**From: WEST SUSSEX COUNTY COUNCIL
LOCAL DEVELOPMENT DIVISION**

**SUBJECT Planning Application No: BE/47/09
Outline application for the demolition of all buildings and
redevelopment of the site with up to 70 dwellings (up to 28
affordable) public open space and strategic landscaping
Chalcroft Nursery and associated land, Chalcraft Lane, Bognor
Regis**

West Sussex County Council would provide the following corporate comments and recommendation on this application.

Scale	1:1000	Drawn By	SAJ	Checked By	CMB	Approved By	PMR
Drawing No.	2009/1046/001	Date	June 2009	Rev.	A

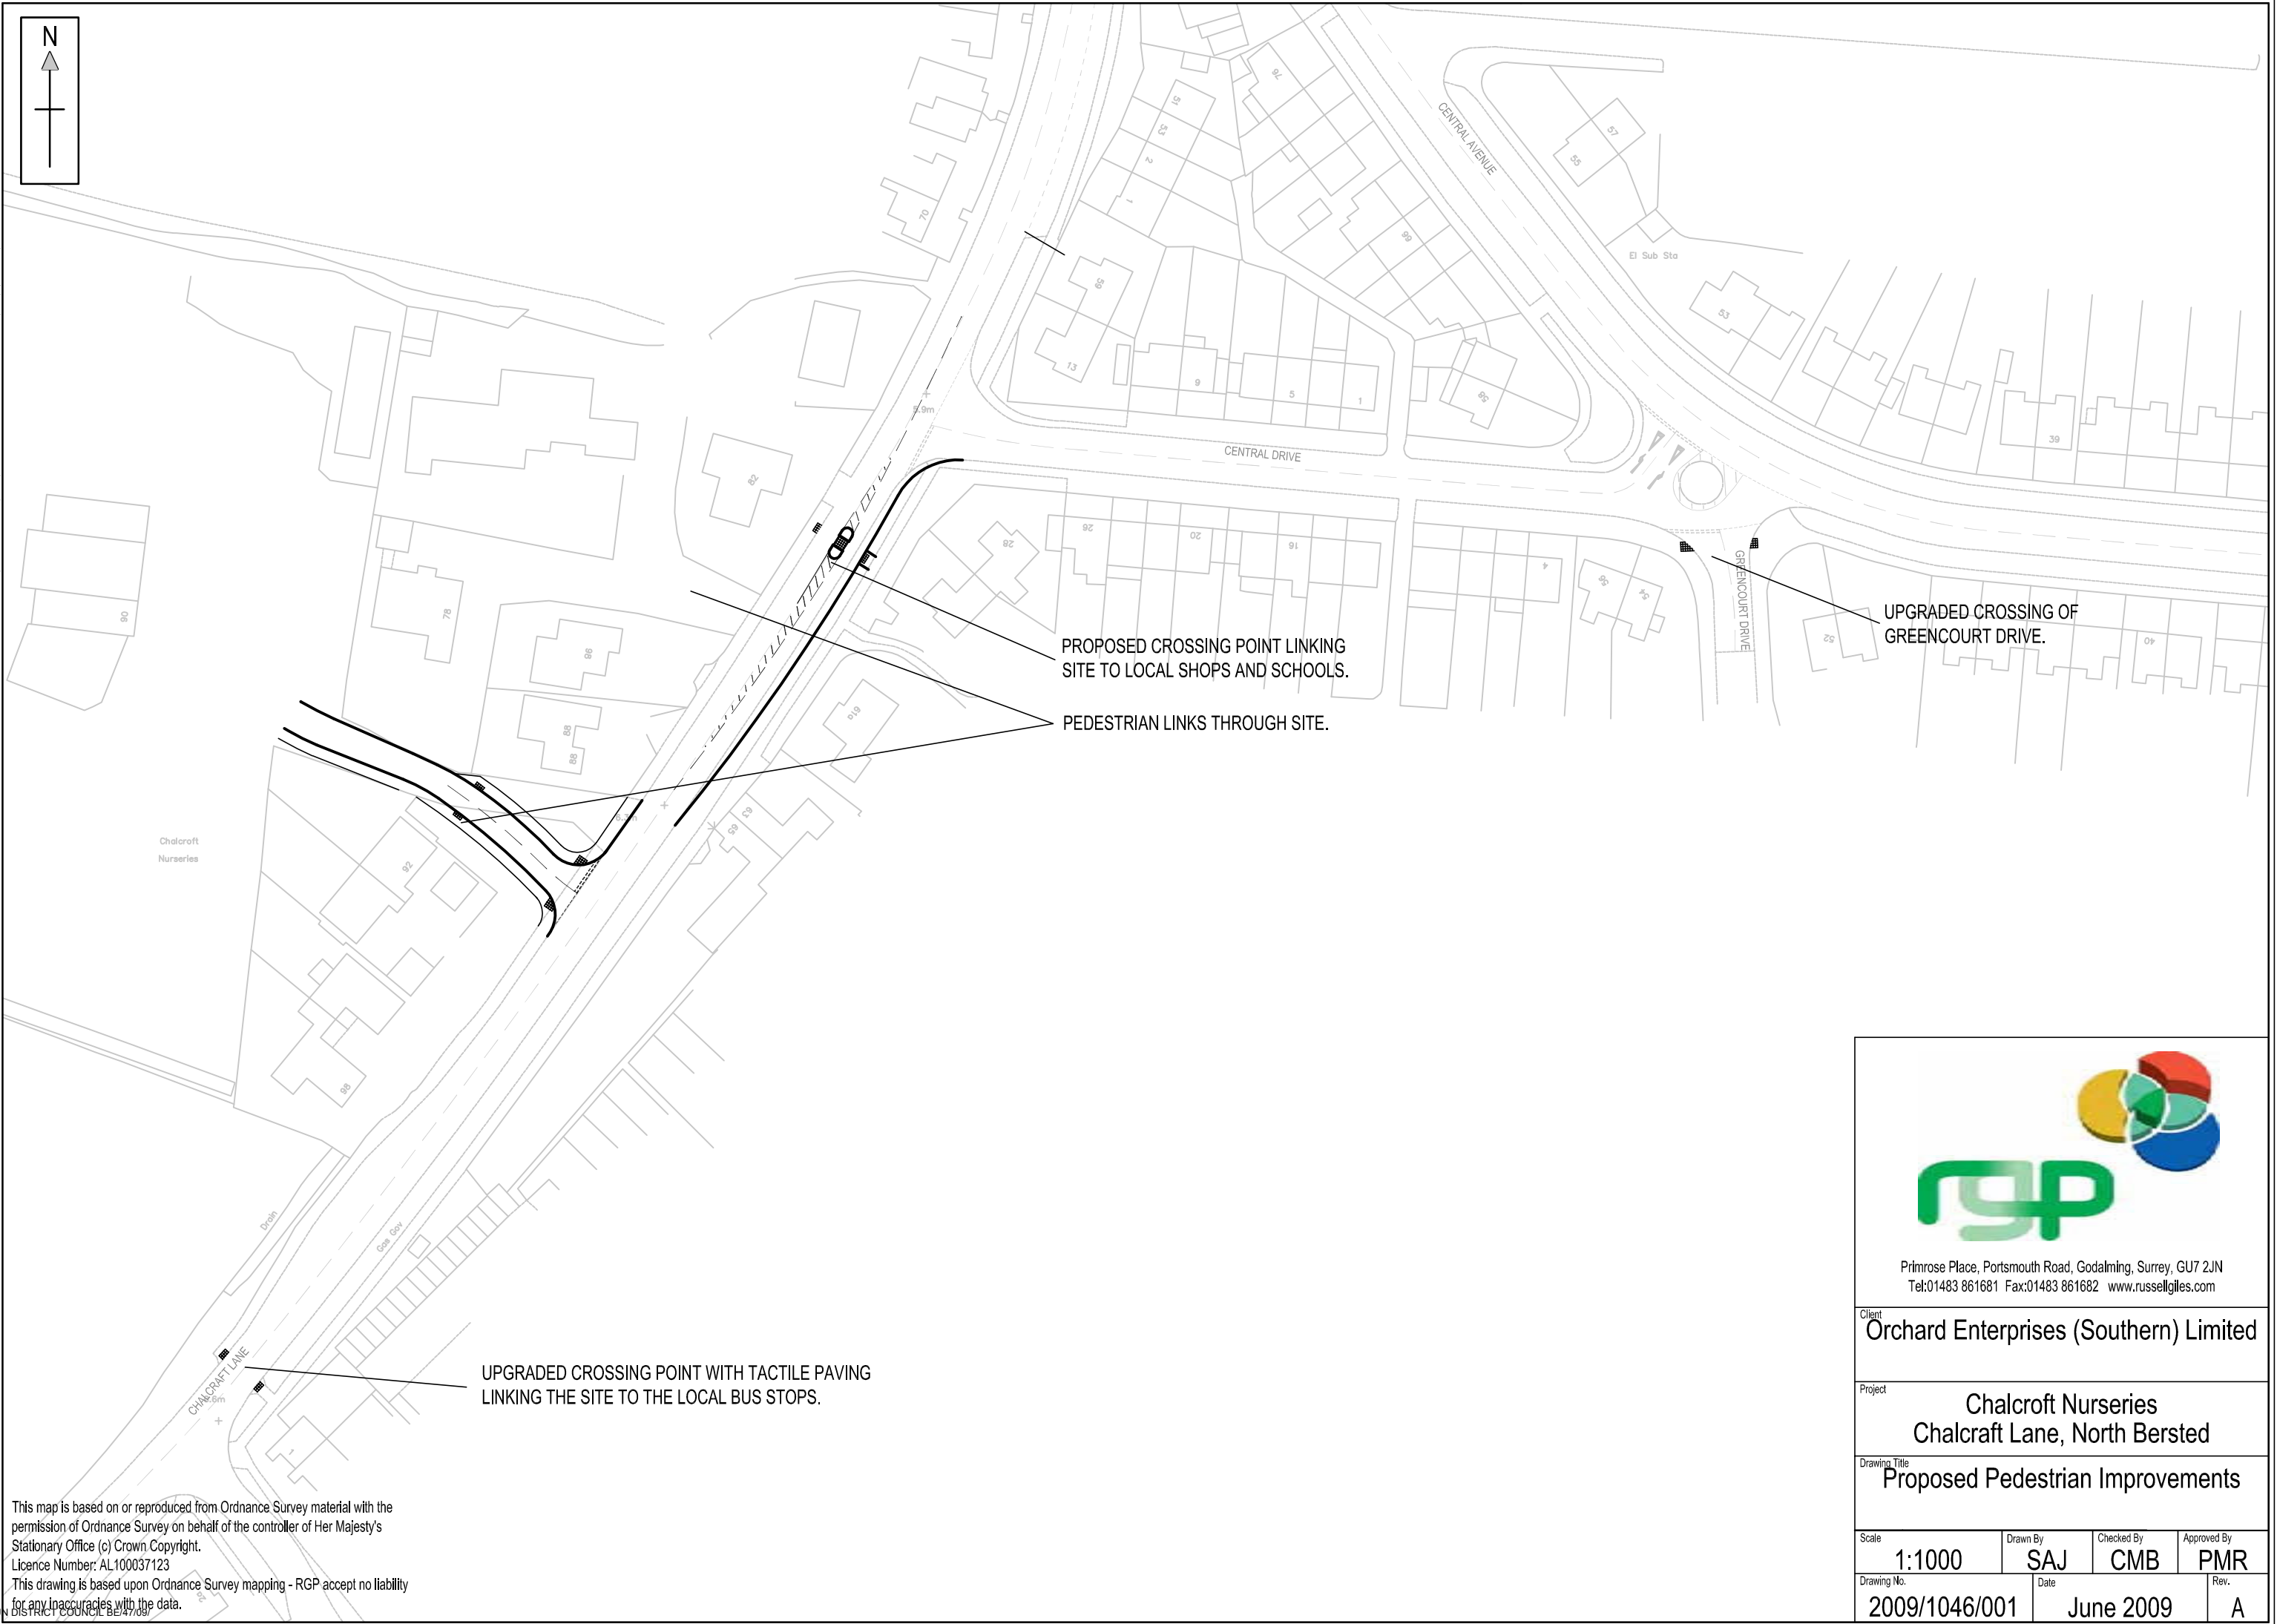
The proposed development includes the provision and upgrade of a number of pedestrian facilities in the local area, in order to maximise permeability to the local shops, schools and buses as shown on drawing number 2009/1046/001. These improvements are summarised as follows.

- (i) Footways would be provided on either side of the proposed site access road, providing safe passage for residents and visitors to the dwellings. Tactile paving would also be provided across the site access road junction onto Chalcraft Lane.
- (ii) A further pedestrian route would be provided from the proposed open space area that would replace no: 78 Chalcraft Lane. The proposals would allow residents to have a pedestrian right of way over the existing vehicle access route.
- (iii) A crossing point would be provided across Chalcraft Lane within the sites pedestrian desire line to the local shops, providing a safe refuge for pedestrians across the busy road. The crossing would also provide a link to the Bognor Regis Community College and would be a popular route for pupils.

- (iv) The existing crossing point to the south of the site would be upgraded with tactile paving to improve links to the local shops.
- (v) Further crossing points would be provided along Central Avenue, crossing Greencourt Drive and Chichester Road, to provide a complete pedestrian route to the local shops.

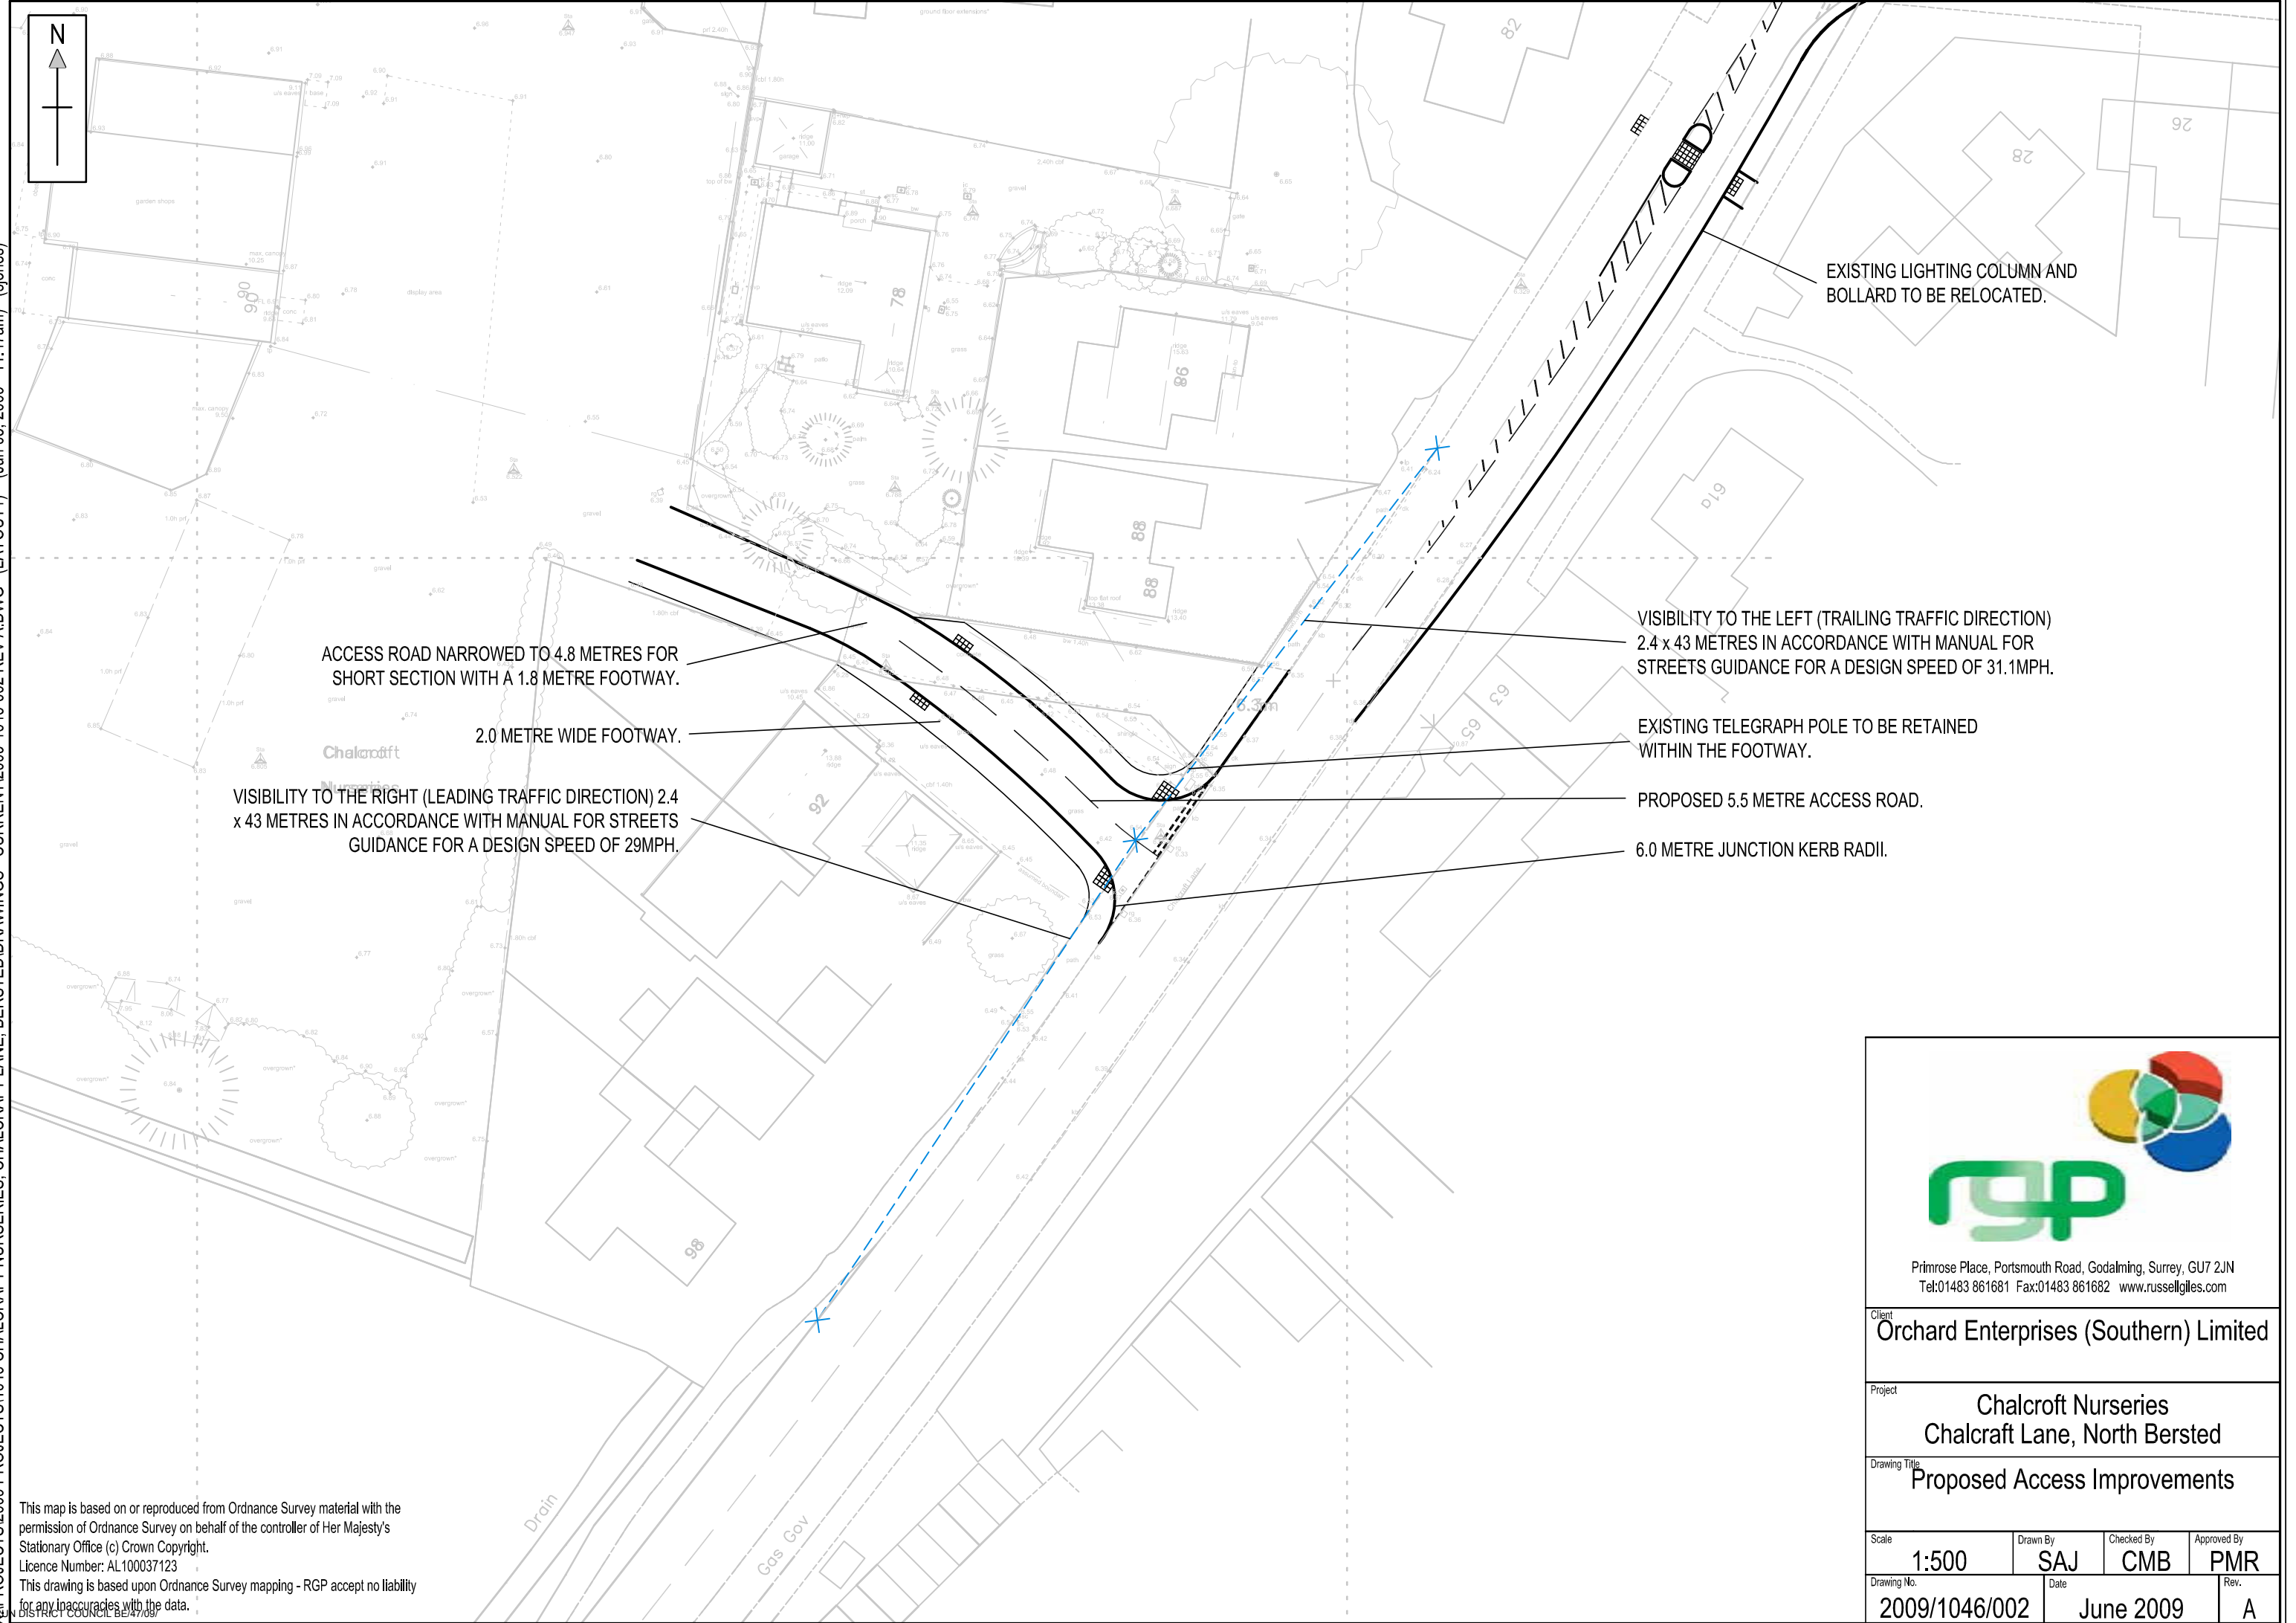
It is proposed to retain and upgrade the existing site access onto Chalcraft Lane to a priority t junction as shown on drawing number 2009/1046/002. The modifications involve providing 2 metre wide footways into the site around 6 metre radii, with a 5.5 metre wide access road and 2.4 metre x 43 metre visibility splays in accordance with the Manual for Streets standard for a 30mph speed limit.

As illustrated o drawing number 2009/1046/002, a narrowing would occur 35 metres into the access road, due to land restraints, providing a 4.8 metre access road with 1.8 metre footways. The localised narrowing would not effect the operation or capacity of the access road.
